Rampion 2 windfarm proposal EN010117

Janine Creaye IP no 20045132

In Response to REP5 – 119 TE 2.32

Quality of field surveys, how the irreplaceable habitat at Cratemans Farm can be avoided or reinstated

Figure 22.3.1k Phase 1 habitat survey
 Extended Phase 1 habitat survey report
 Environmental Statement

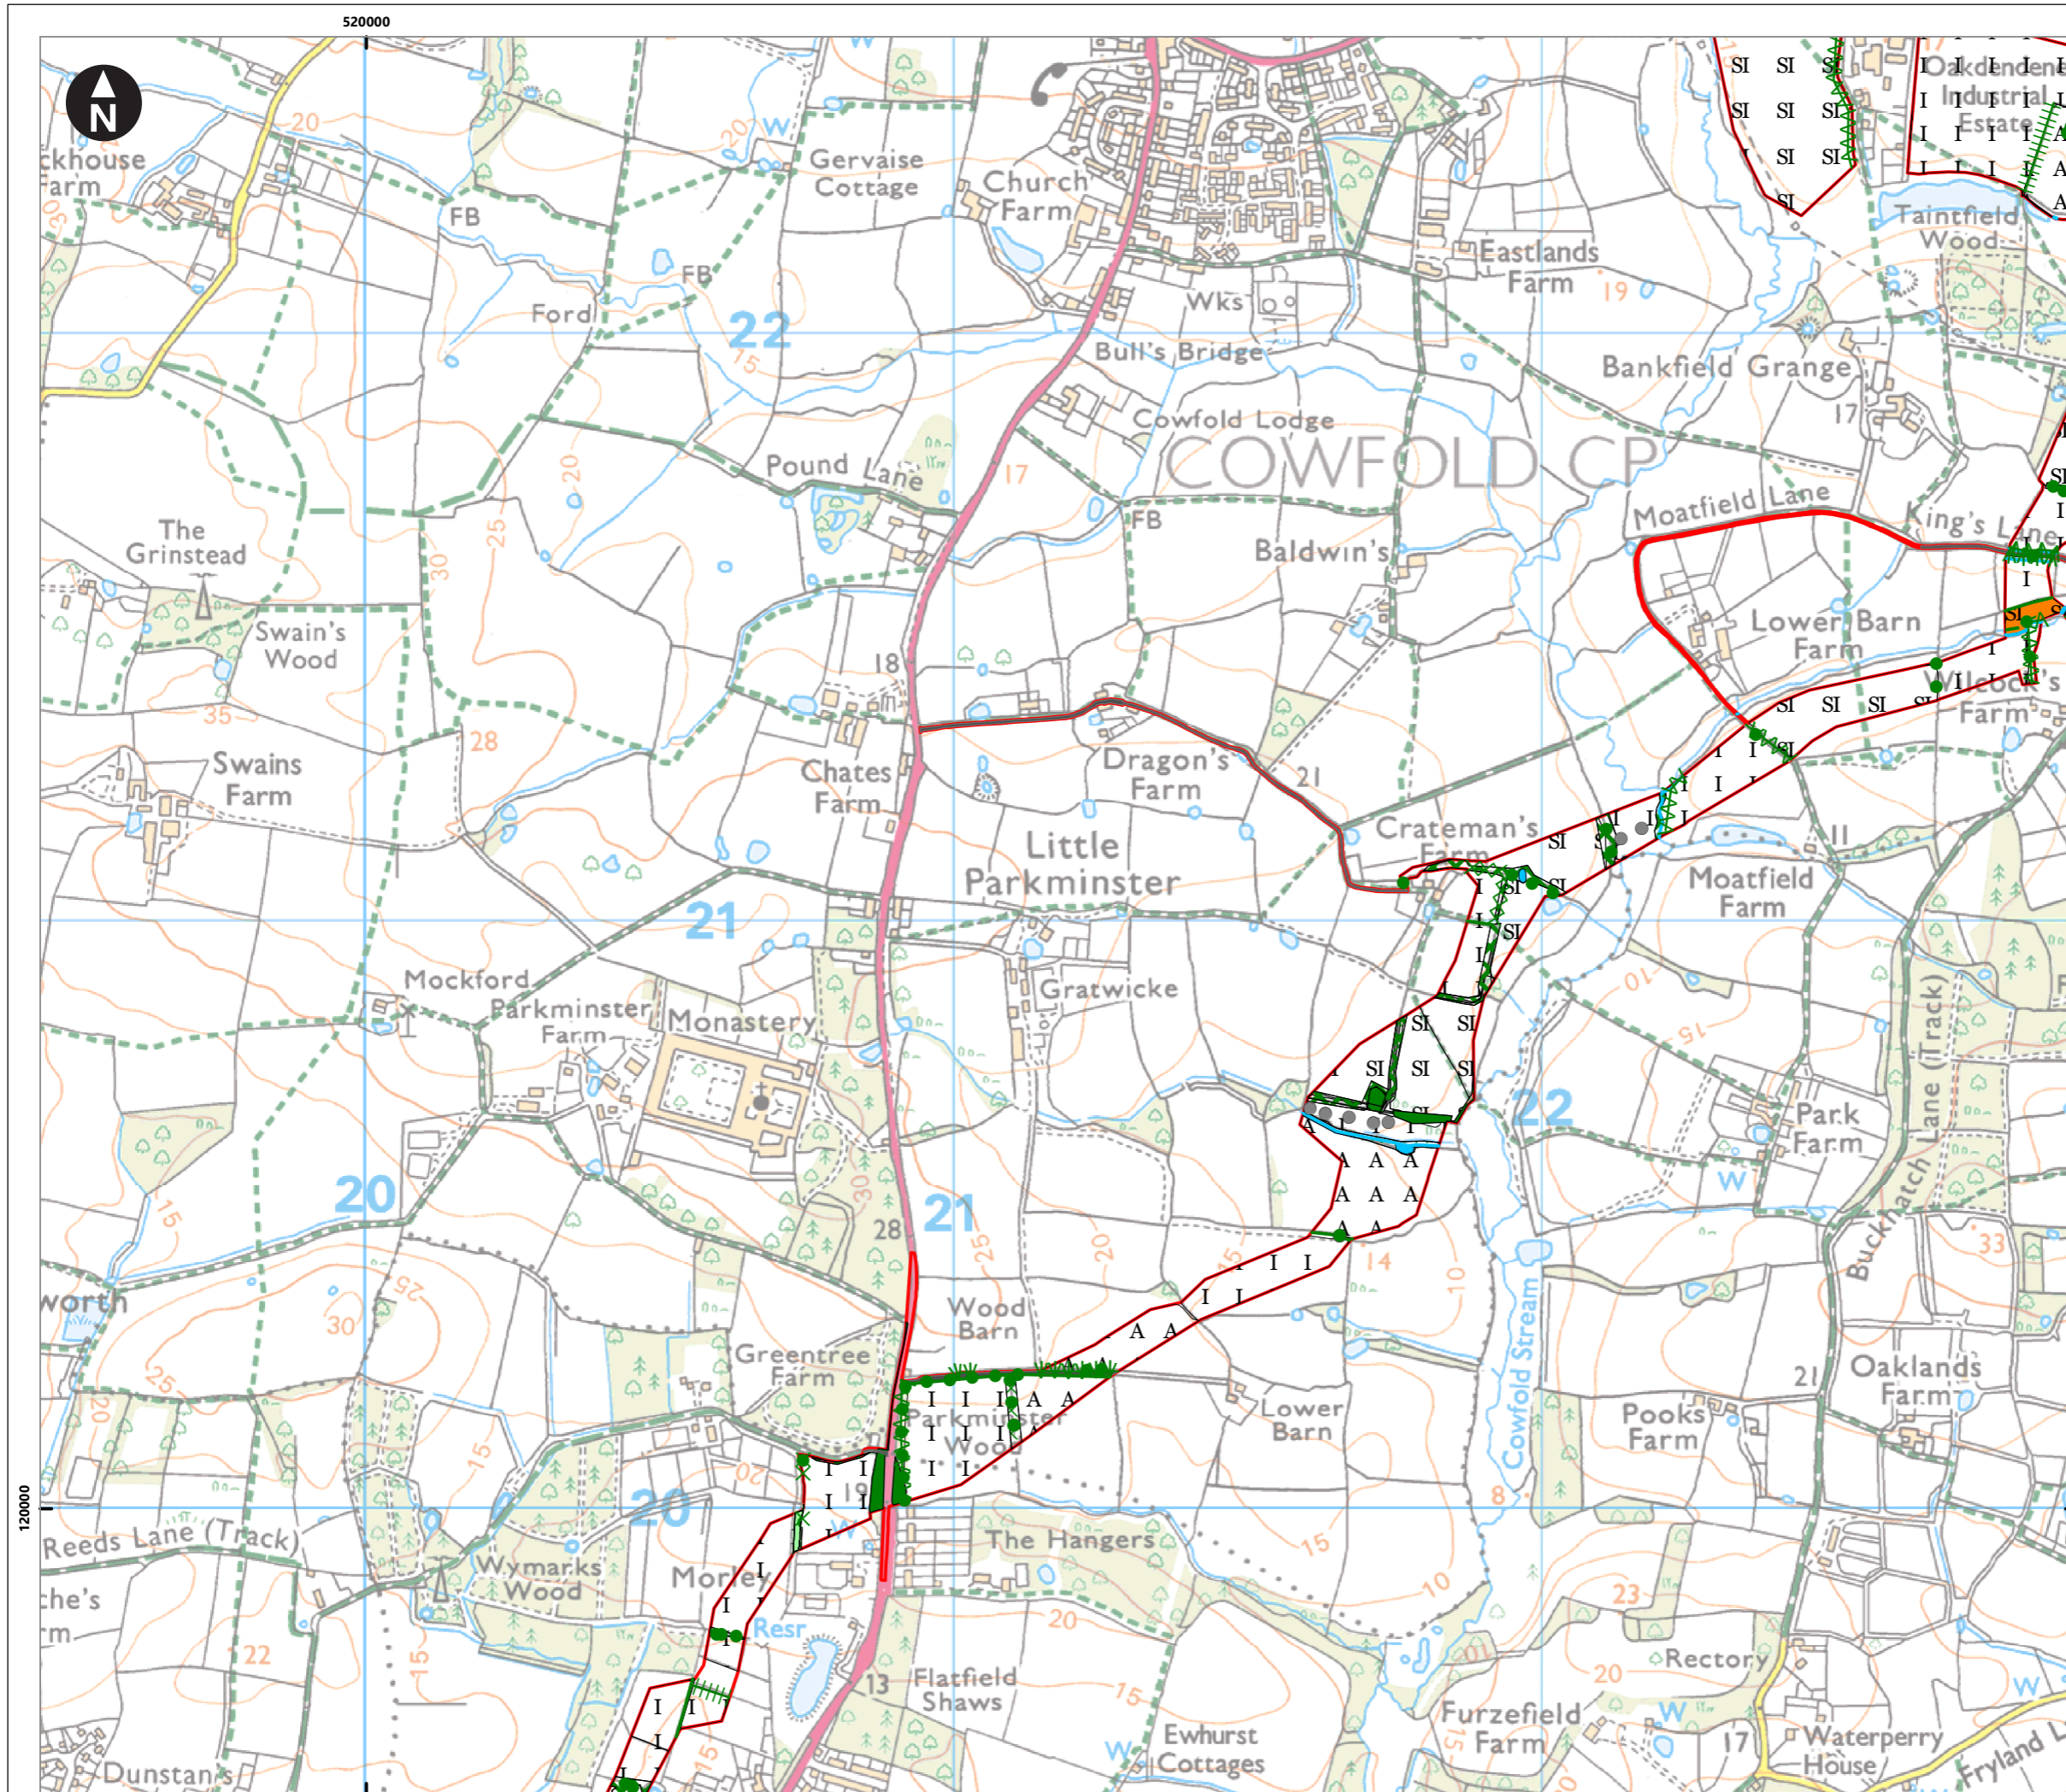
The context of this wildlife haven is that either side either side the farms have cleared big fields of hedge and scrub and the ground has been turned over destroying all chance of meadow quality for the foreseeable future. The use of selective herbicides is the norm on adjacent land. The recent blackthorn clearance right down the Cowfold Stream either side has allowed Himalayan Balsam to flourish as never in previous years, further destroying the opportunity for blackthorn and native wildflowers to reestablish by the stream banks. I don't believe that it is being understood by the authorities how unique the wildlife quality is at Cratemans Farm within this District. It is not just the fields we have picked out to survey but the whole site is treated much the same (without the use of artificial fertiliser, pesticides or herbicides for over 60 years), and each has heightened biodiversity in slightly different ways partly depending on slopes and flooding habits. There is absolutely no 'improved' grassland as marked on the Applicants phase 1 habitat survey maps for here (Fig 22.3.1k).
